CITY OF ALBUQUERQUE

August 5, 2013

**Re: Lots 1-a, 1-B, 1-C, 3 Lot Subdivision SE corner of Oakland and Louisiana
Grading and Drainage Plan
Engineer's Stamp date – no stamp-(C19D059)**

CITY OF ALBUQUERQUE  
PUBLIC WORKS DEPARTMENT  
ENGINEERING DEVELOPMENT GROUP  
**VISTA OAKLAND SUBDIVISION**  
BEING A REPLAT OF LOT 1, BLOCK 3, UNIT 3, TRACT 2, NAA  
GRADING & DRAINAGE PLAN

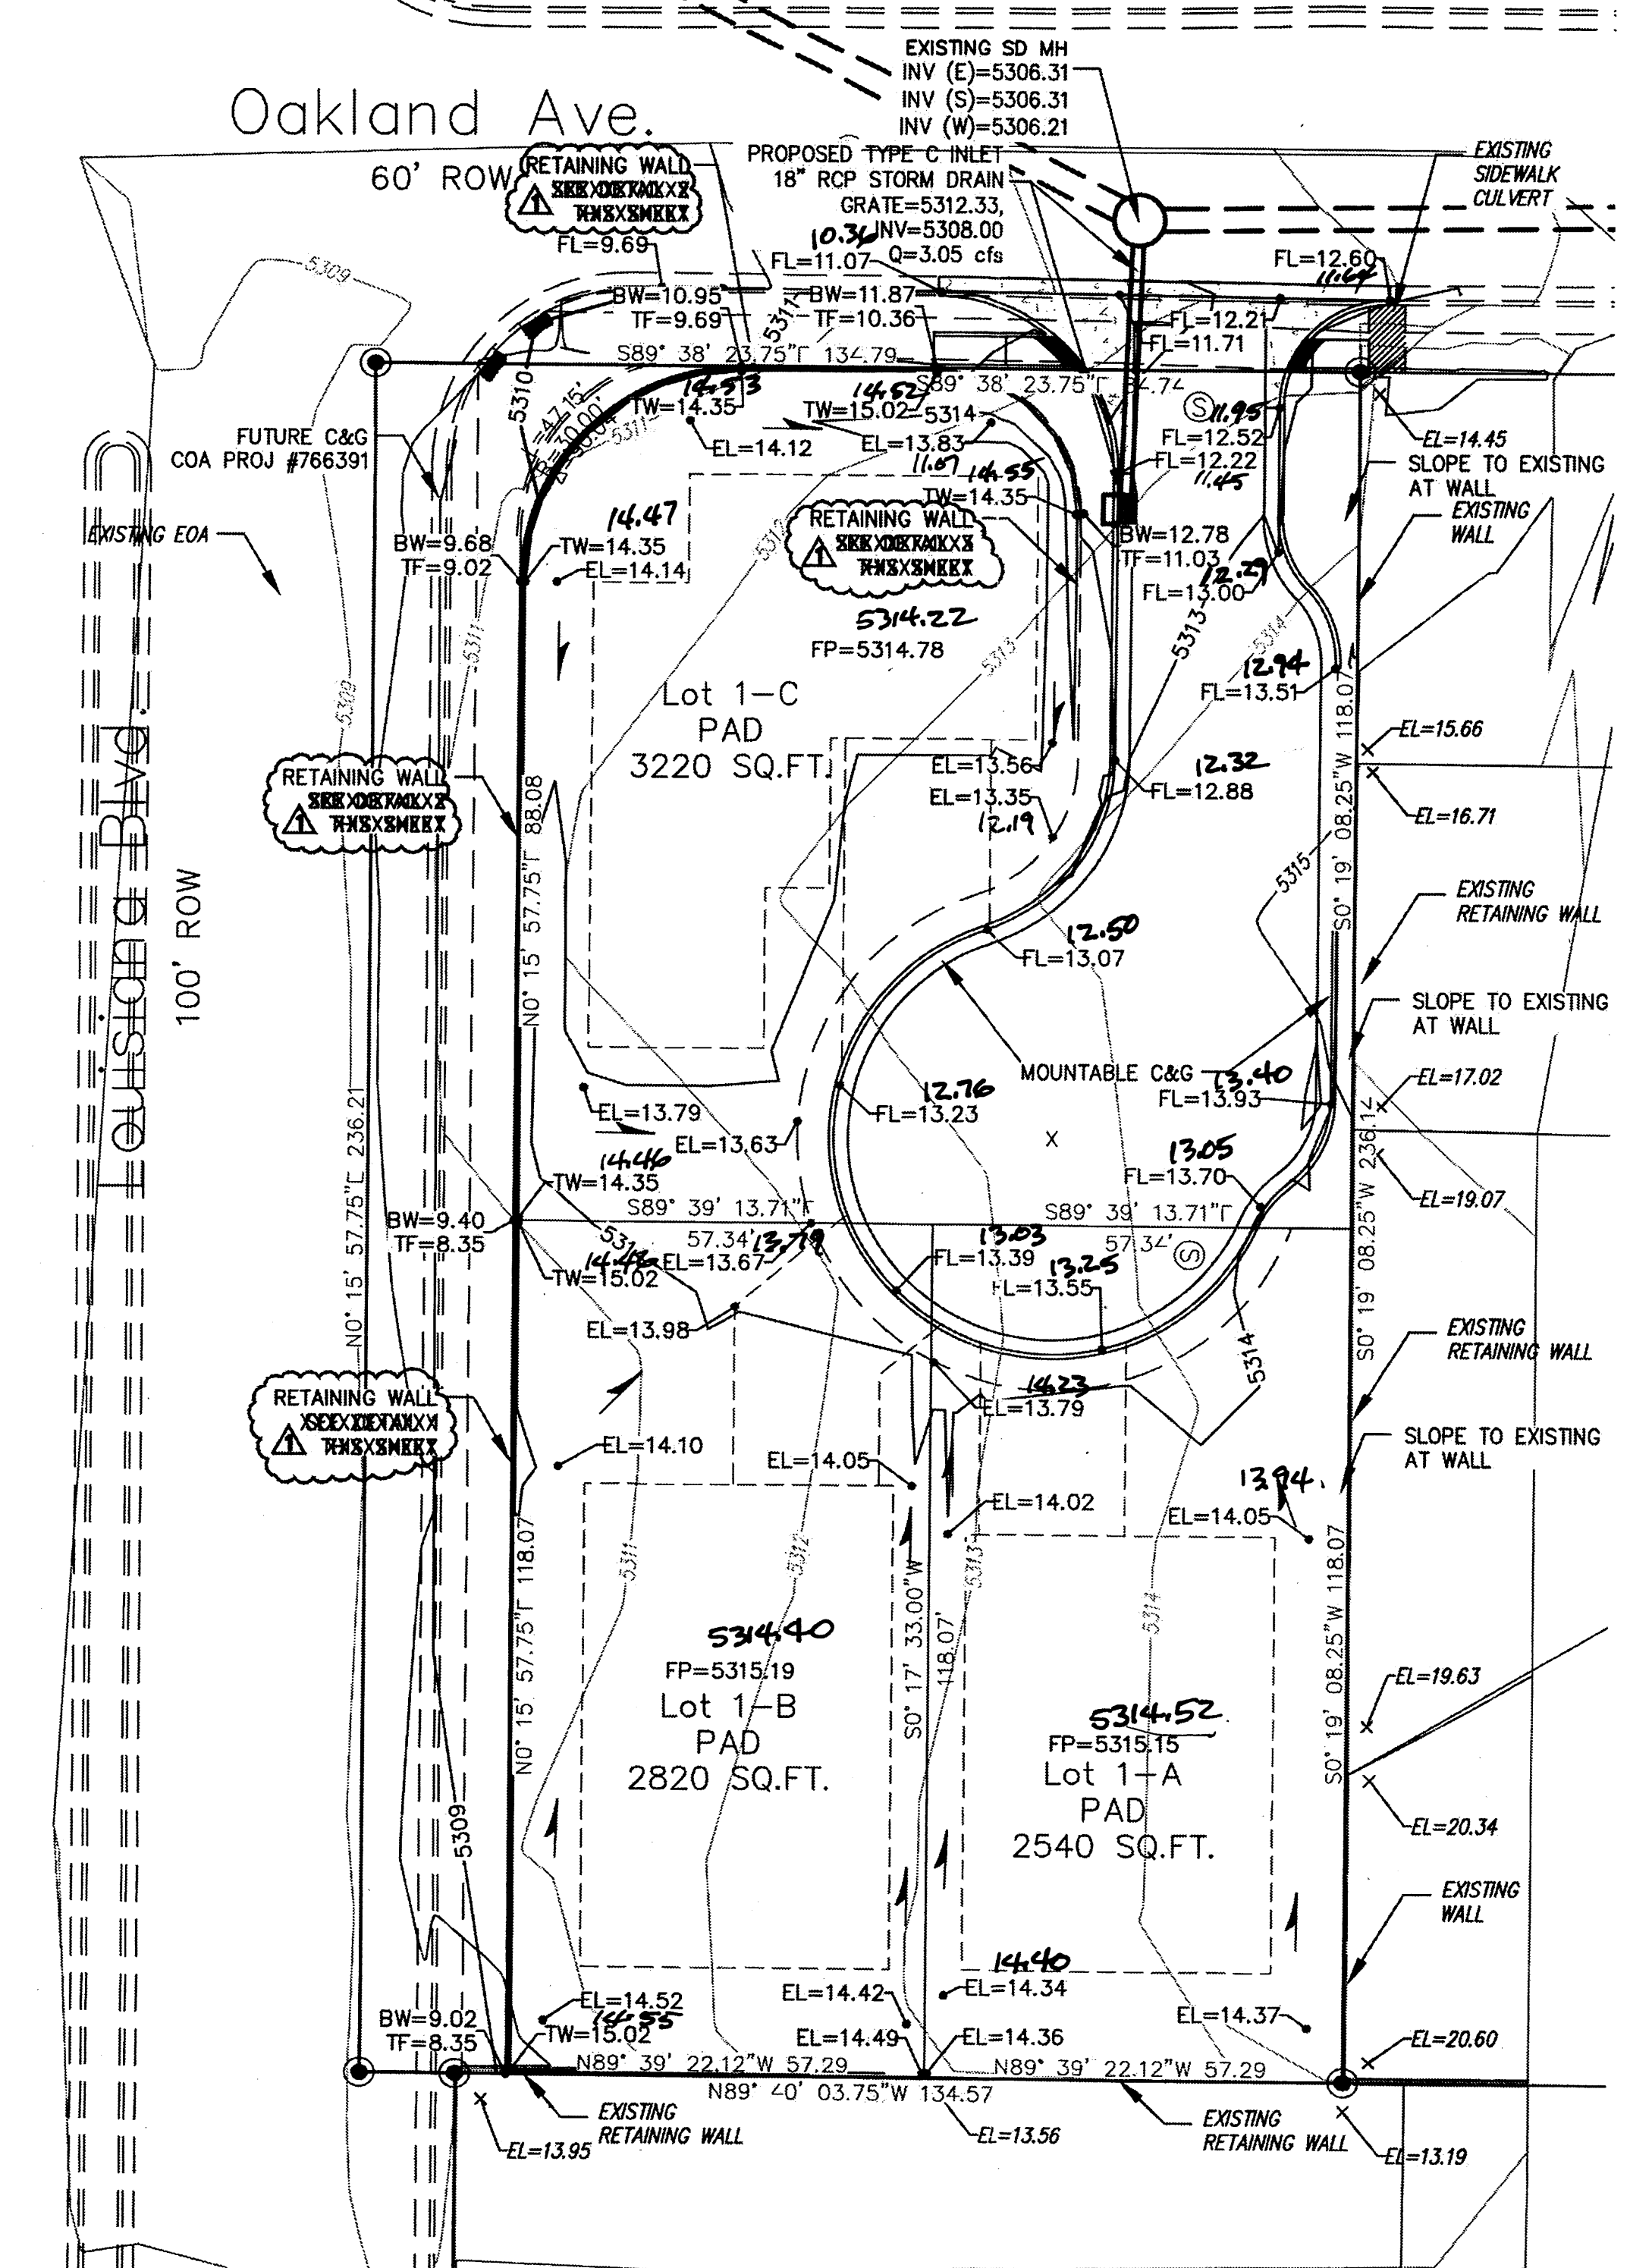
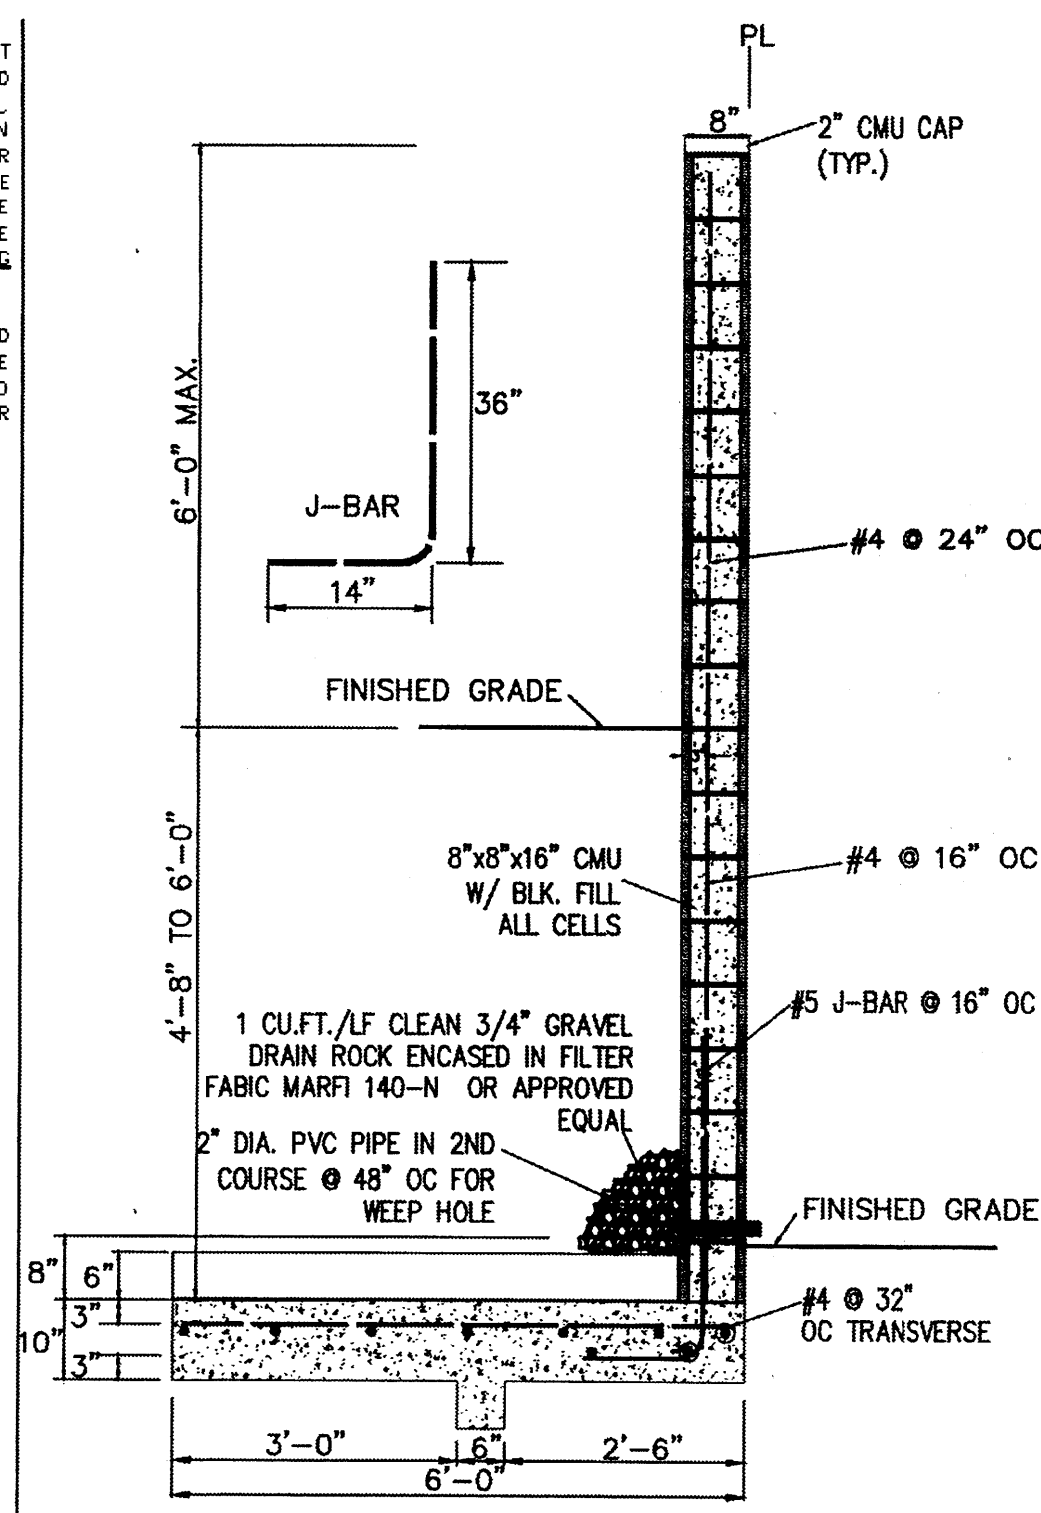
1. The Quail spring Subdivision Pond Reclamation grading plan, C19D015A, shows 2-6" (? , not extremely clear) SDR 35 drain pipes extending to the face of curb in the area where the east curb return is proposed. How will drainage from these pipes be accommodated? Show relevant grade information.
2. Hydrology could not determine the bottom of wall elevation for the existing flood wall, not retaining wall, along the eastern edge of this subdivision. Since you are proposing lowering the grade on the downhill side, the footer may be exposed. Provide information regarding the elevation of the wall footer.
3. The plan is to be sealed by a licensed PE.
